19 April 2016

**Re: Exhibition of State Significant Development Application for Warehouse and Distribution Centre, Prestons (SSD 7155)**

DRAWING TITLE	INDICATIVE EARTHWORKS FLAT PAD & INDICATIVE VOLUMES
DRAWING No	C08753.11-DA30
ISSUE	G

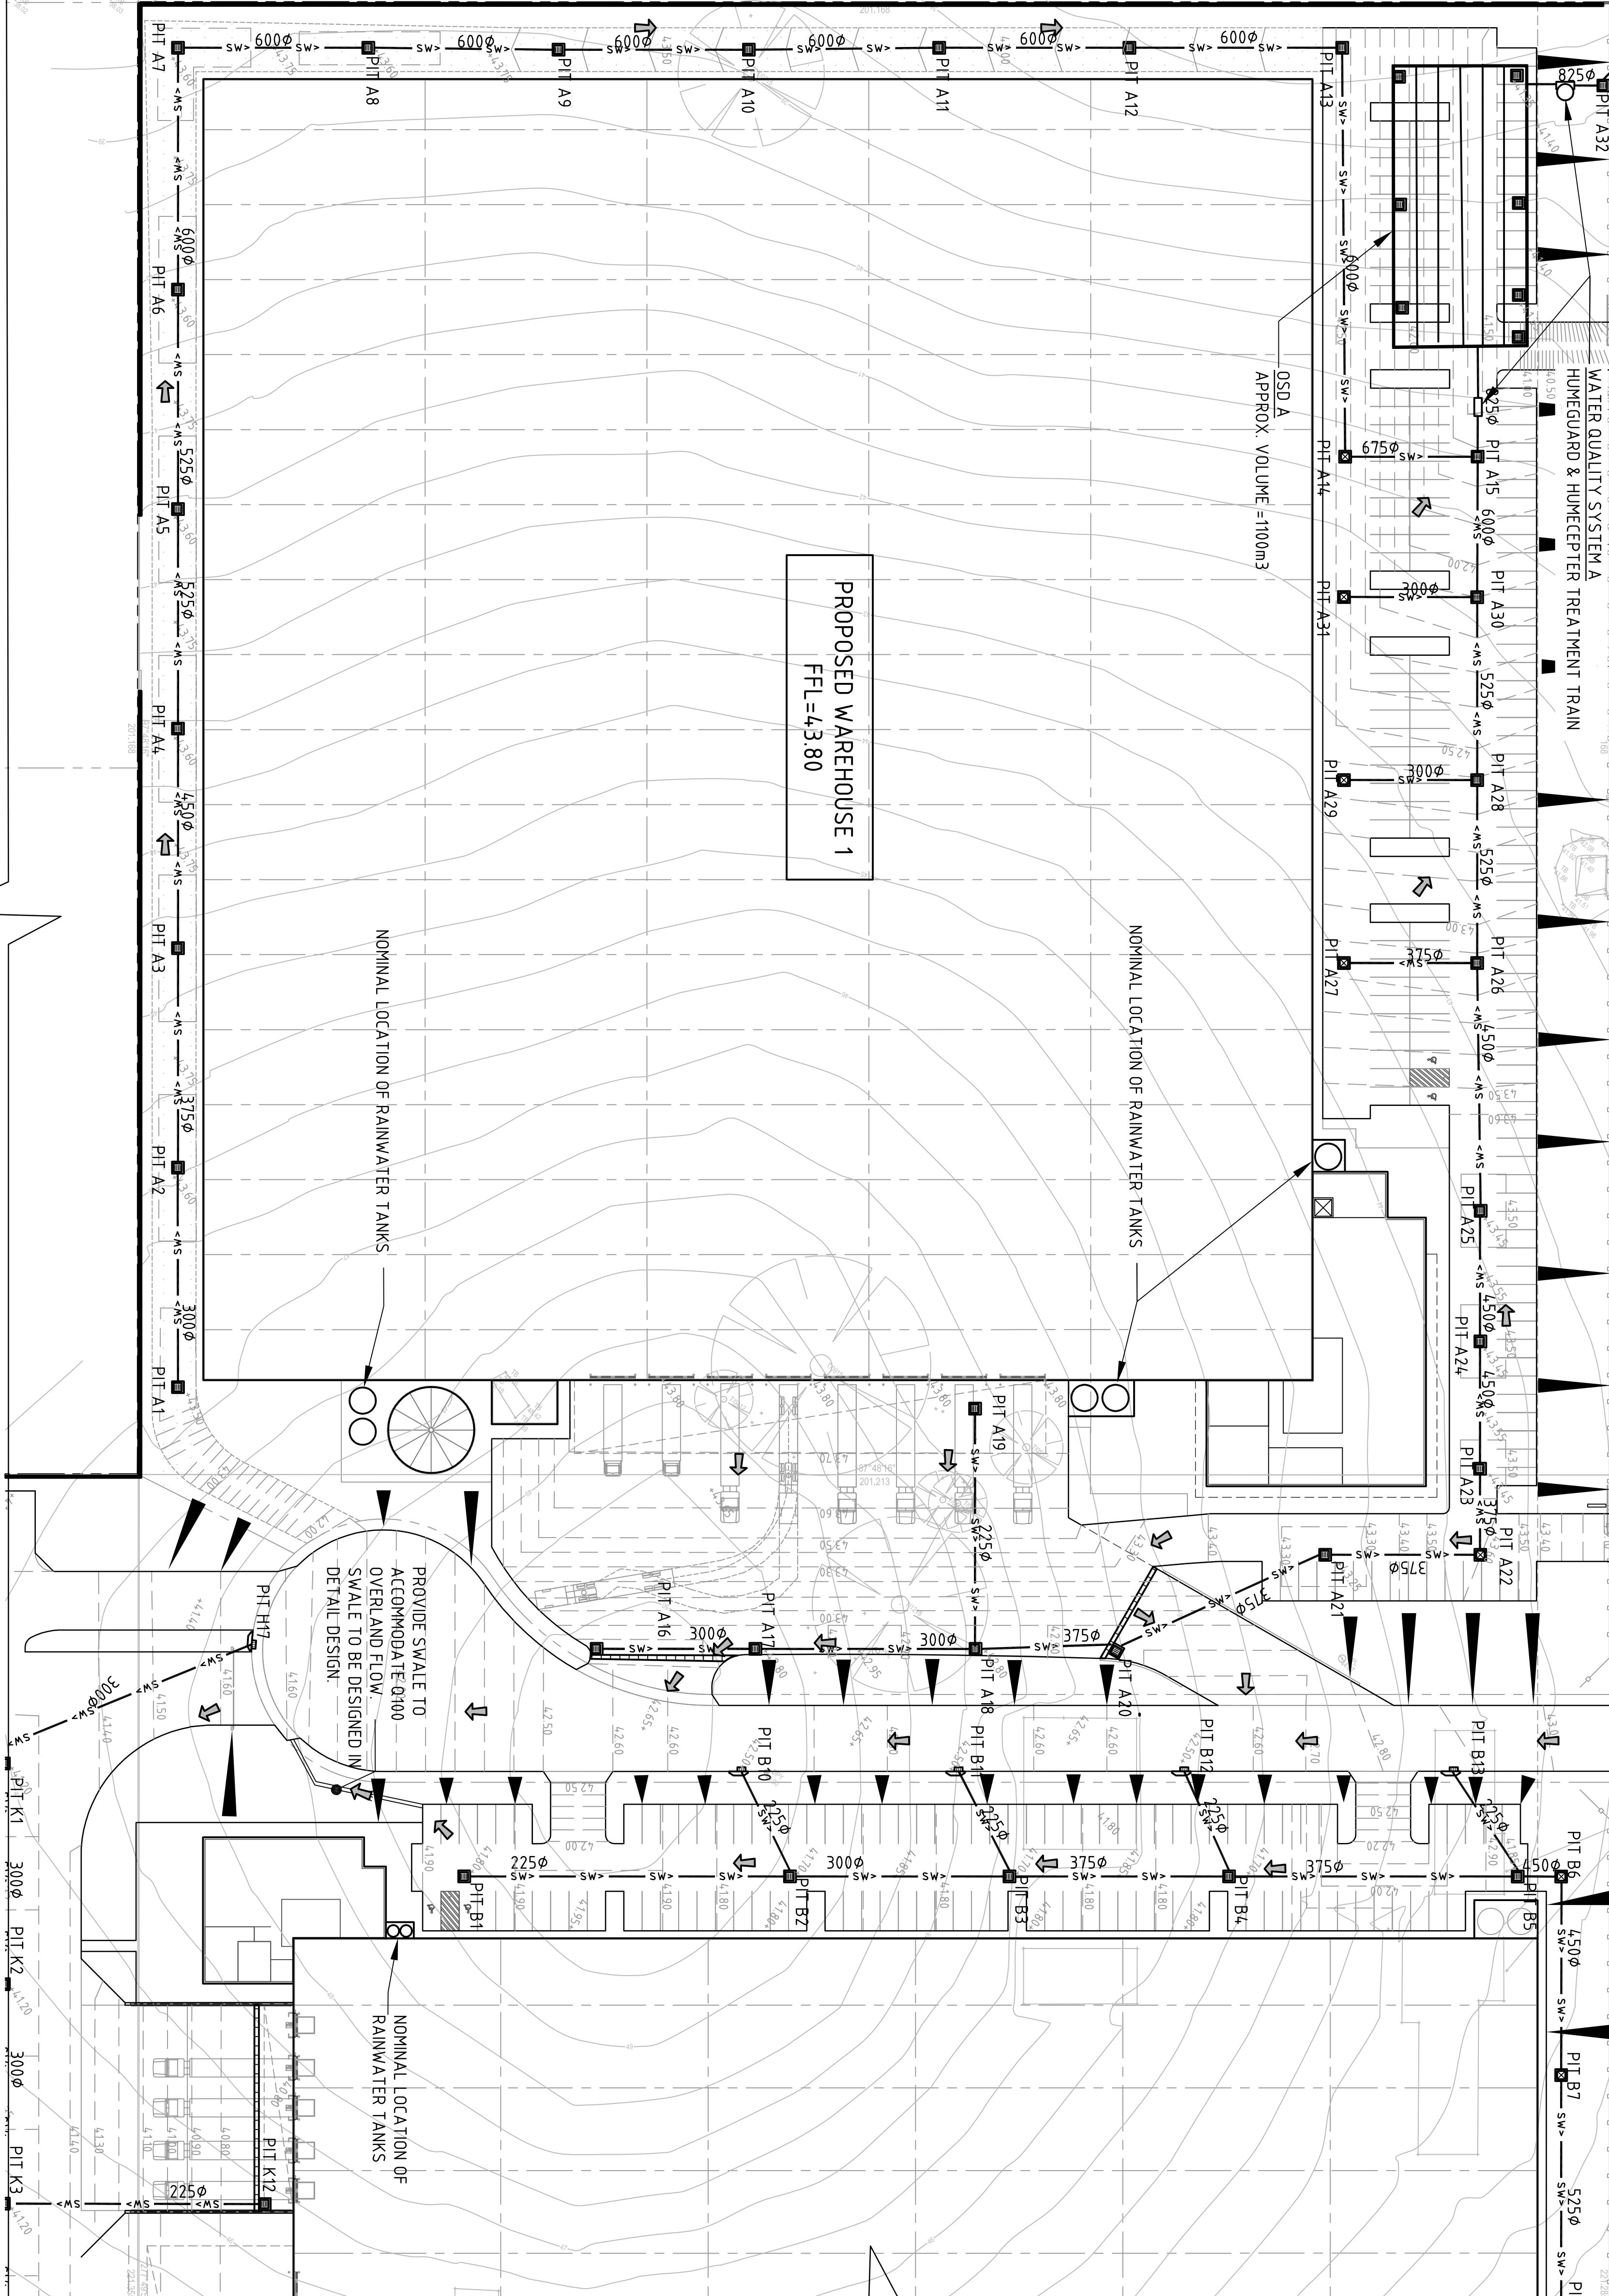
The proposed stormwater management strategy involves collection and discharge of stormwater runoff from the upper (southern) catchment area via a combination of trunk drainage culverts and overland flows across the proposed development. The proposed drainage system will end at the existing culvert under Bernera Road. A small portion of the discharged flows will be conveyed via the existing culvert under Bernera Road with the remaining major flows being overtopped on to the Bernera Road over a short width of the road as point discharge.

Council considers that the proposed discharge of stormwater runoff onto Bernera Road will damage the road structure and would have adverse flooding impacts on private properties. Council's concern has been raised with the applicant and it was agreed that necessary design modification will be undertaken.

Council recommends that the discharge of flows on to Bernera Road be regulated in a controlled manner to ensure existing flow conditions, including flood levels, velocities and the extent of flooding, are not increased. Council has provided the flood model developed for catchment to the applicant's engineers for the preparation of a flood impact assessment.
